## **Development Facilitation Team (DFT) – Review Comments**

**Project No: PR-2023-008993**

**Location: 8400 FLORENCE between BARSTOW and VENTURA**

### **Application For: VA-2023-00307-SIDEWALK WAIVER (DHO)**

COVER SHEET, SITE PLAN, & THERMAL BYPASS DETAILS
 PROJECT NAME: HOWARD RESIDENCE

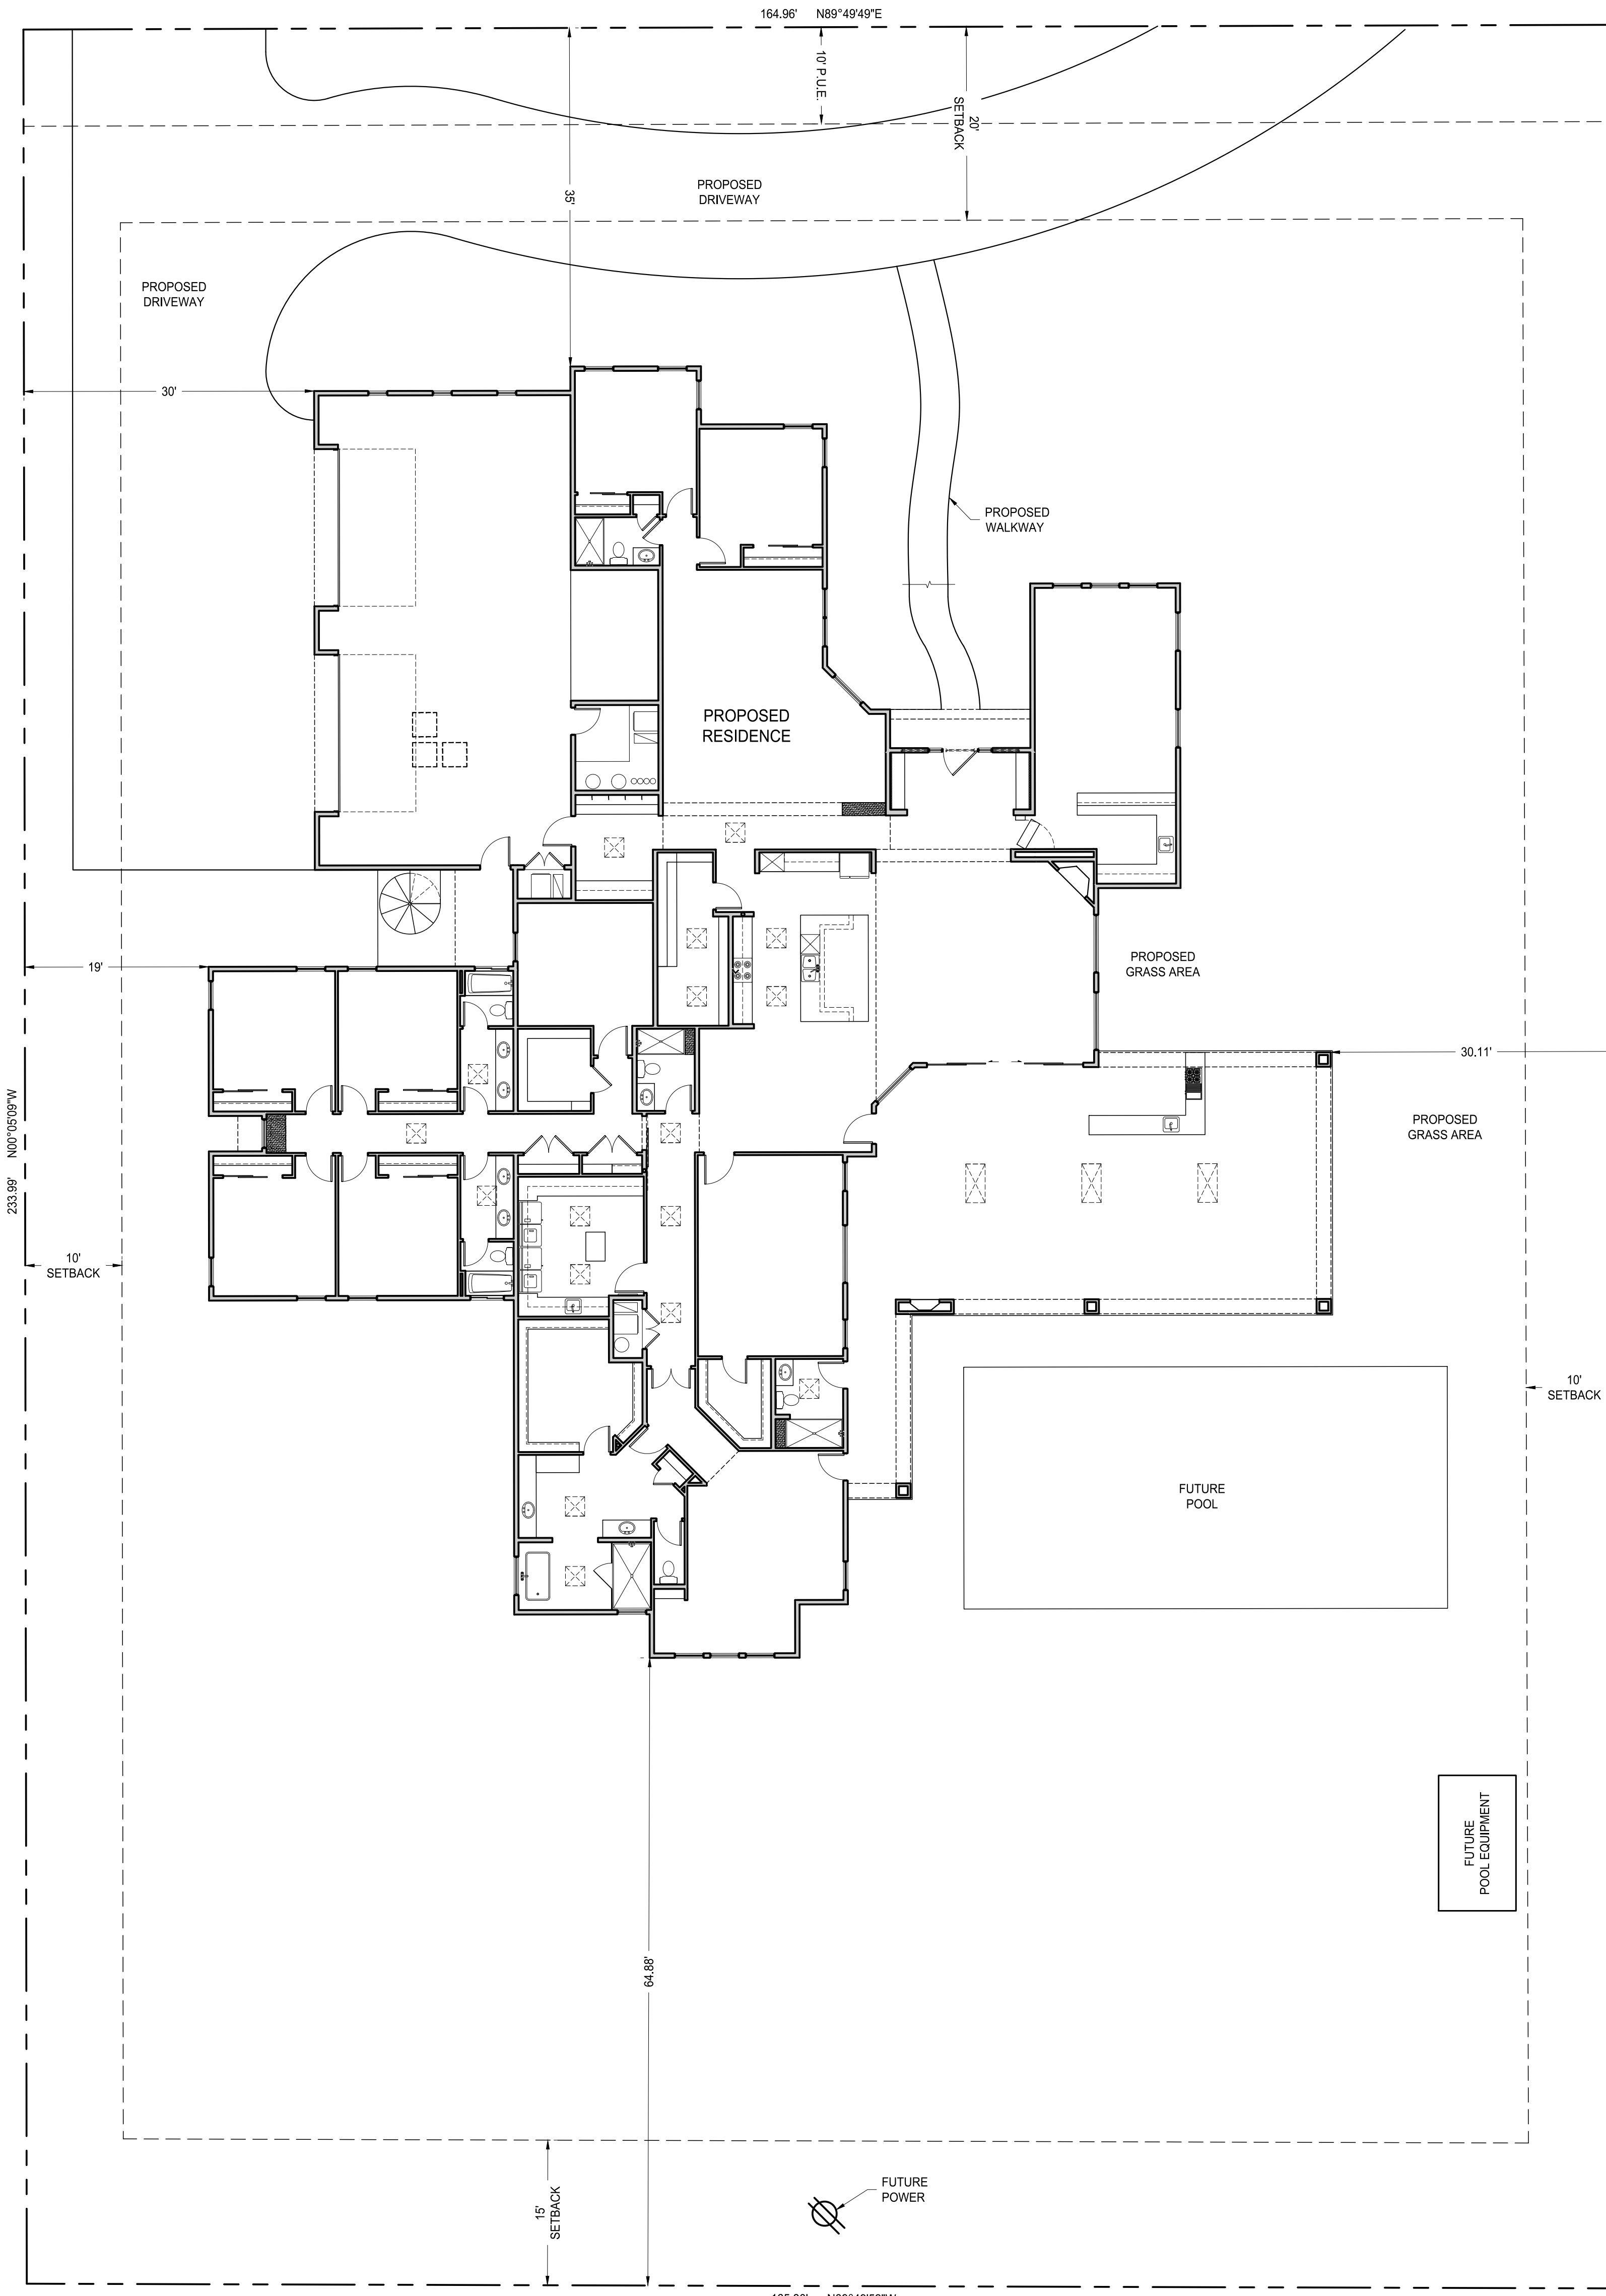
1. Florence is a Local street and requires curb and gutter and a 5' sidewalk with a 4-6' landscape buffer. Unfortunately, we are not able to waive the requirements of curb, gutter and sidewalk for this area. Transportation has been directed to enforce this requirement in this part of the City.
